Re: Proposed Various Extensions and Rooms within Roof Area.

At: 49 Bank End Road, Worsbrough Dale, Barnsley. S70 4QJ.

Application No: 2016 / 0741.

PROJECT	Various Extensions	
CLIENT	Mr. & Mrs. S. Kelsey	
TITLE	Elevations as Proposed	
ADDRESS	49 Bank End Road, Worsbrough Dale, Barnsley. S70 4QJ	
DRAWN BY	ggg	
SCALE	1:100	DATE June 16
DRAWING No	833-04	REV

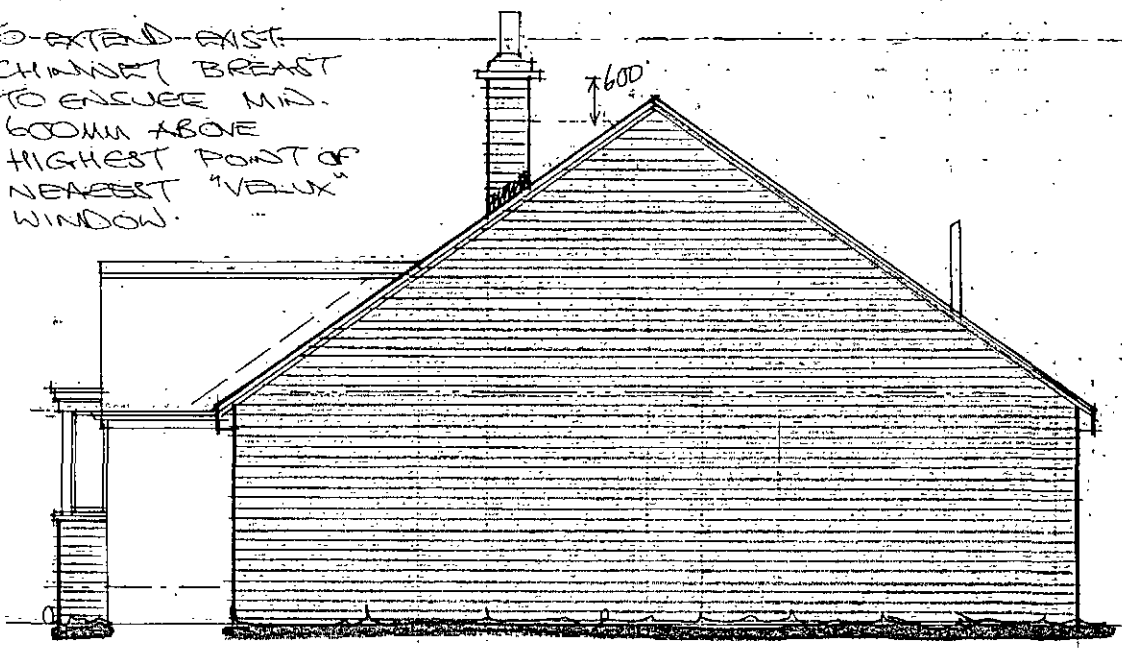
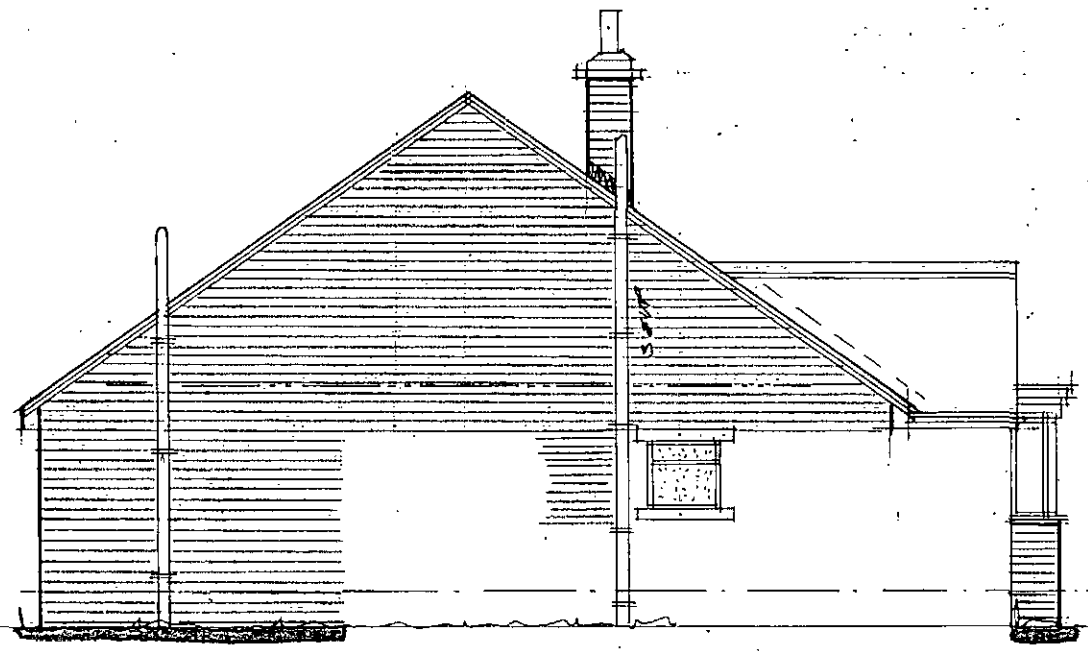
Further to our recent discussions with regards the above project, please find attached copies of information as listed below now amended hopefully to your requirements, namely the reduction of the ridge line as agreed to the proposed side extension adjacent No. 51 Bank End Road.
